Markup Summary

Subject: Callout
Page Label: 1
Lock: Unlocked
Author: dskendall
Date: 12/18/2018 12:10:26 PM
Color: ■

Site Plan Drawing for Project: Norton Extended Family Guest House

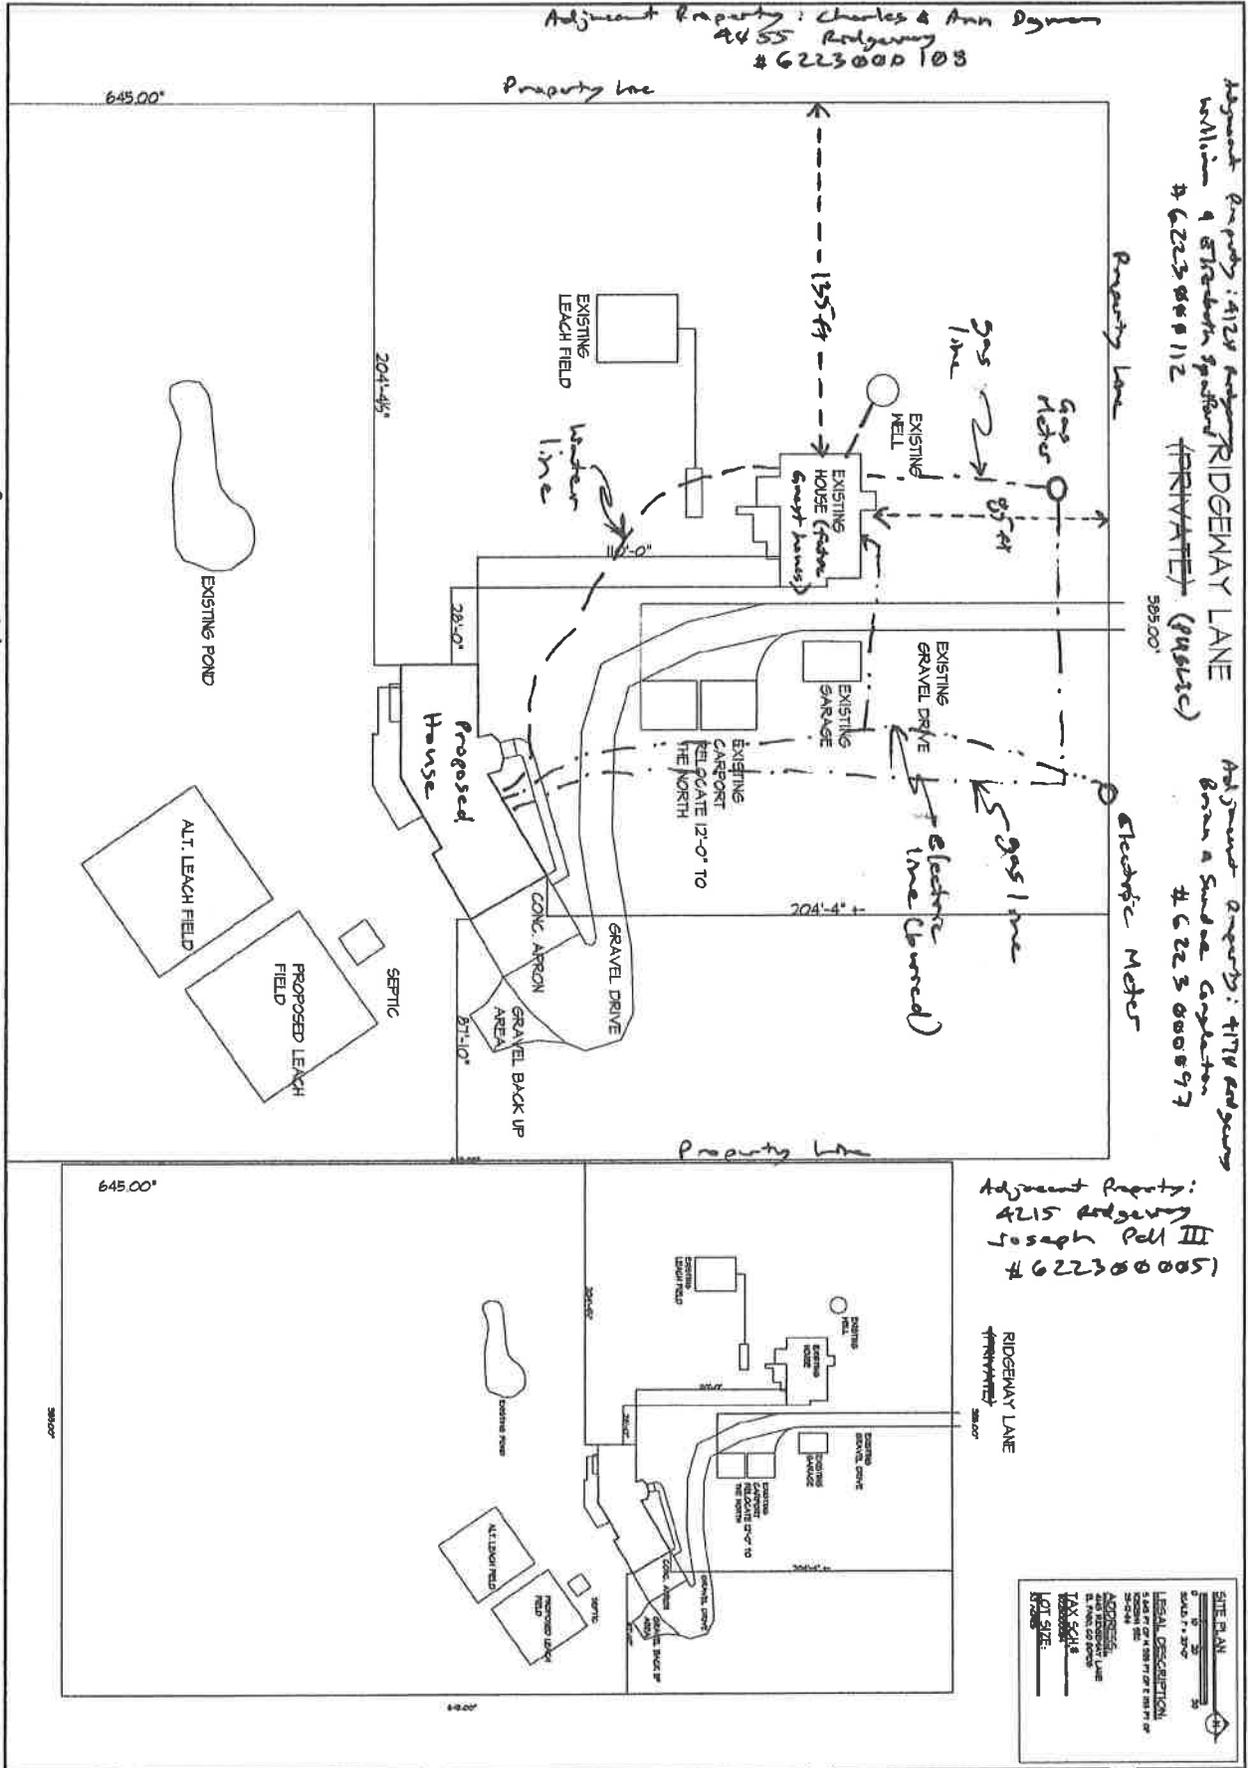
Label proposed house.

Show setbacks from closest structures to property lines.

Show utility lines connecting from meters.

Make the measurement lines dashed so they are different from the structure lines.
